From: Hornby, Mark [Mark.Hornby@lancashire.gov.uk]
Sent: 24 January 2012 14:15
To: Graeme Thorpe
Cc: ENV EPP Customer Service Area East
Subject: FW: Consultation on planning application 3/2011/1050 land at Waverley Road, Ramsgreave
Graeme

I have no objection to this proposal, subject to the following condition:

SITE PLAN

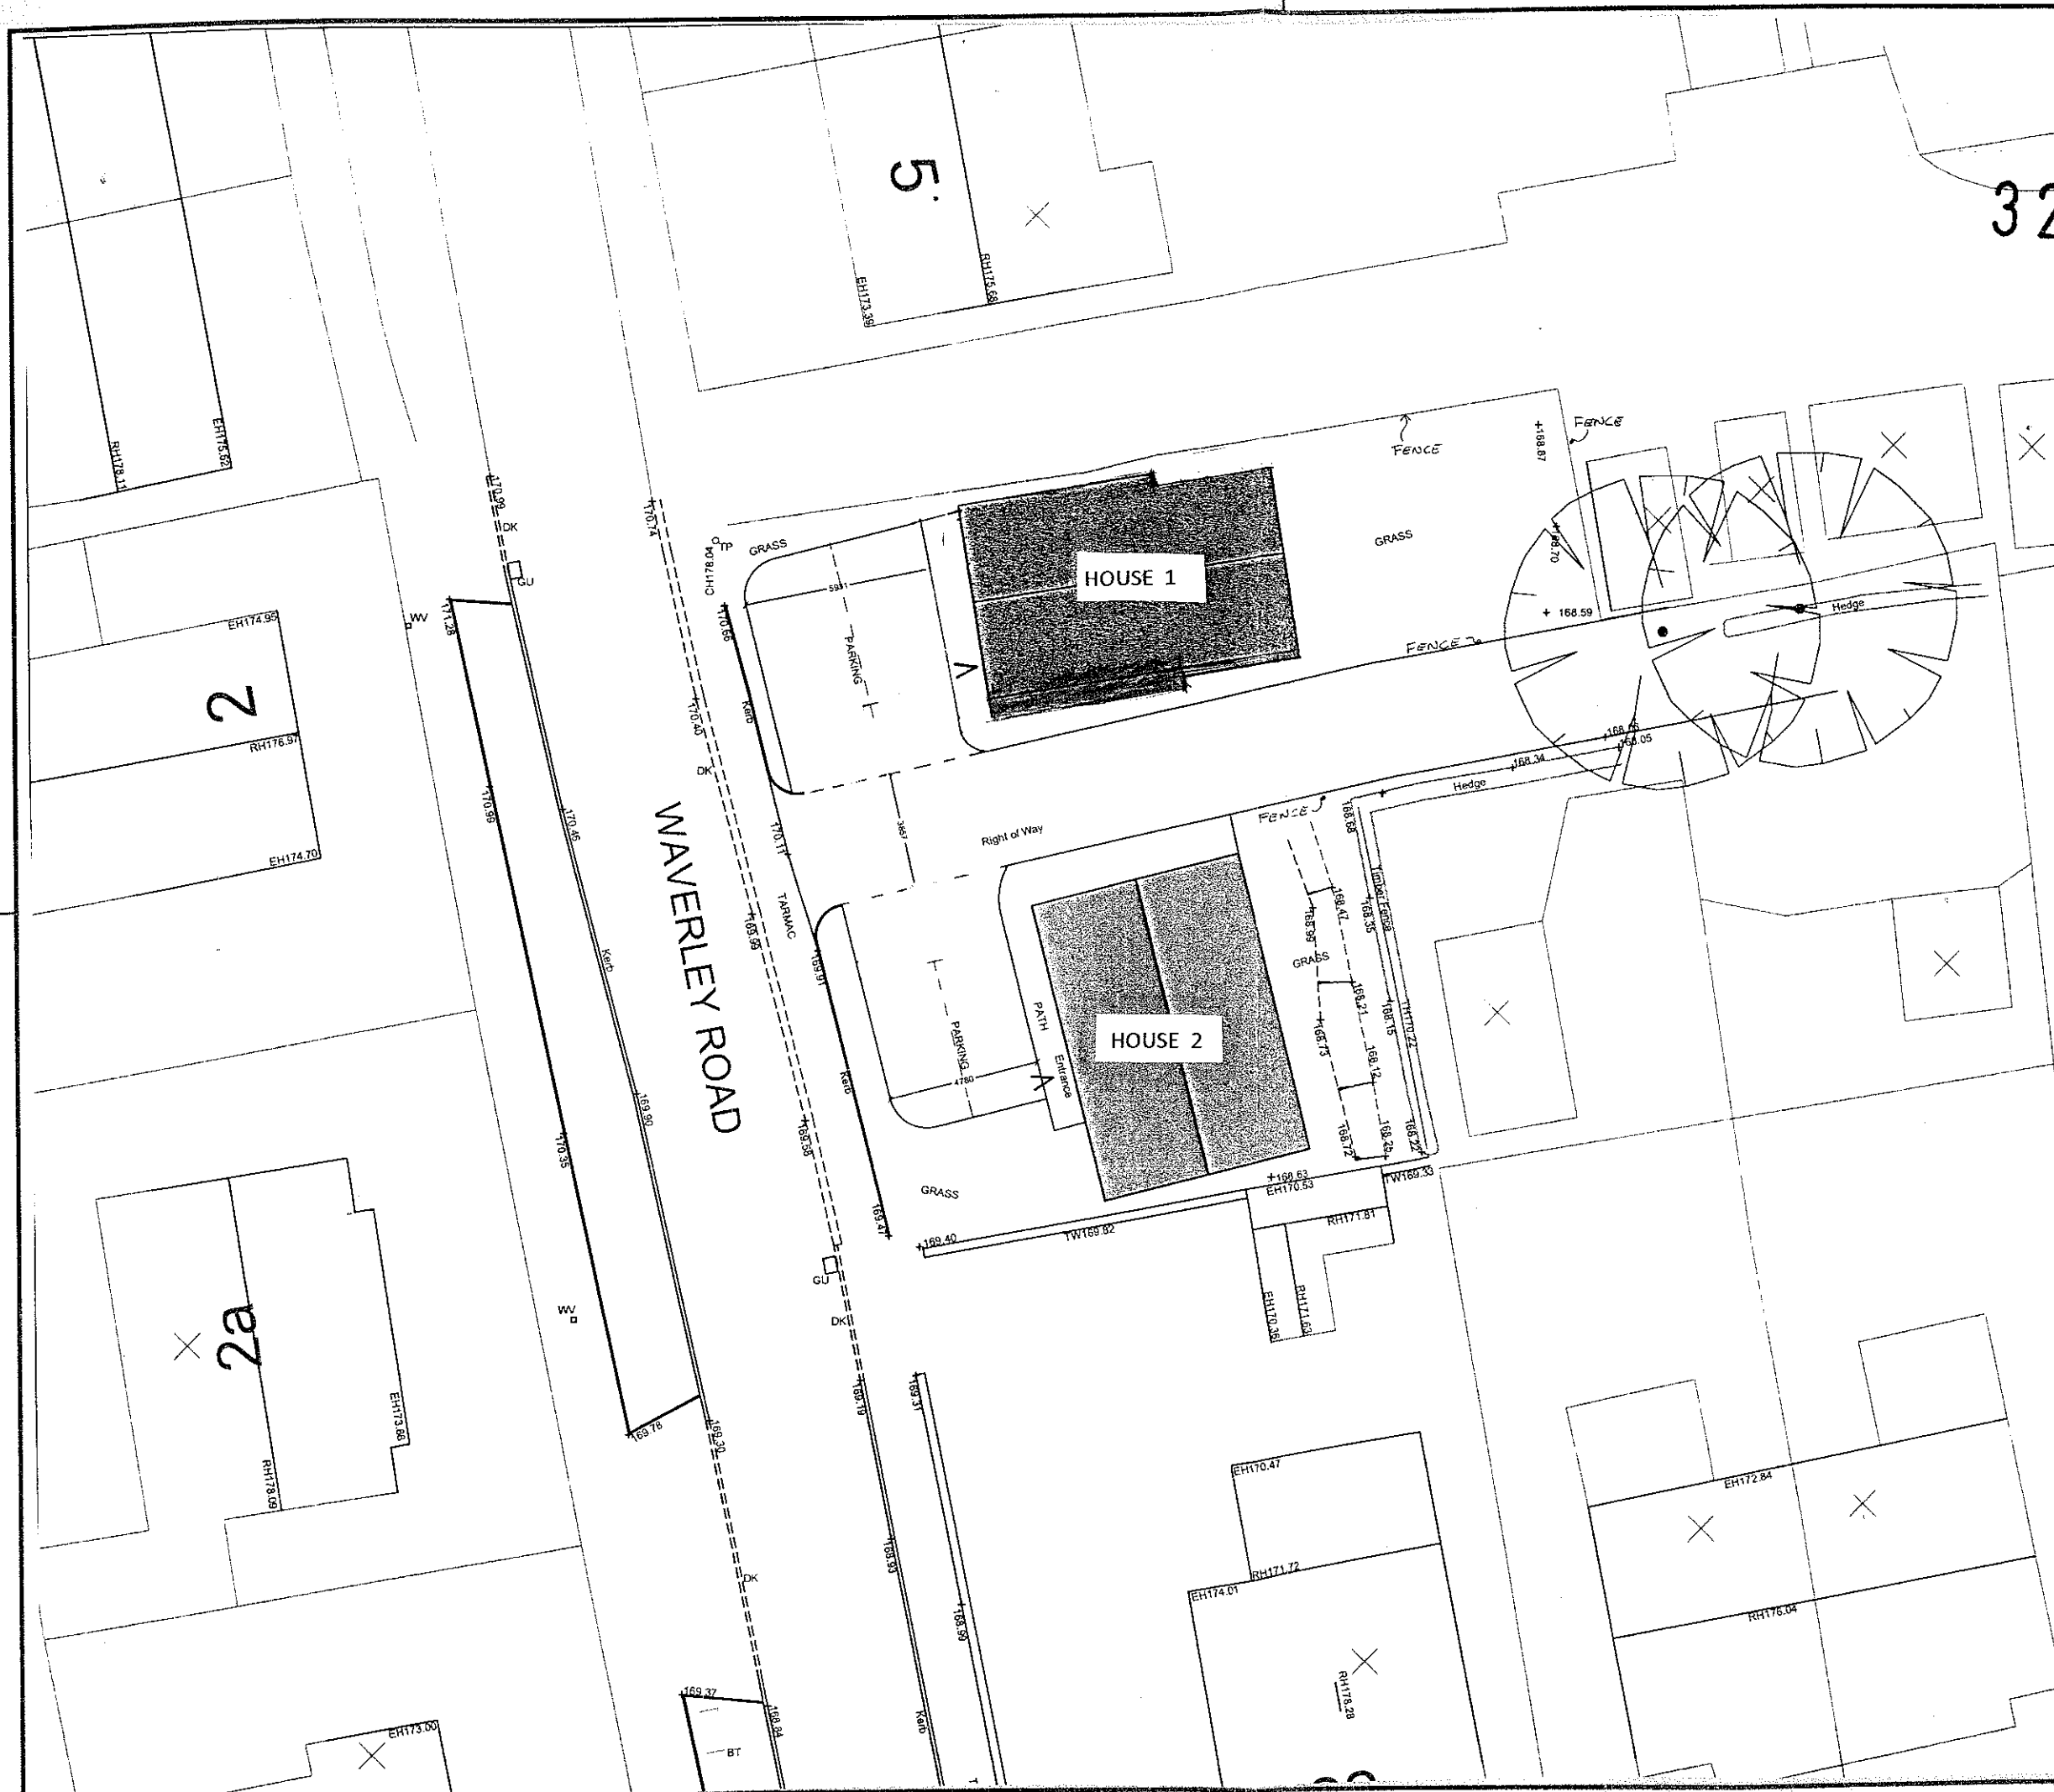
The parking area for each of the two dwellings and the existing access track between the parking areas shall be appropriately paved in tarmacadam, concrete, block pavements, or other approved materials. Reason: To prevent loose surface material from being carried onto the public highway thus causing a potential source of danger to other road users.
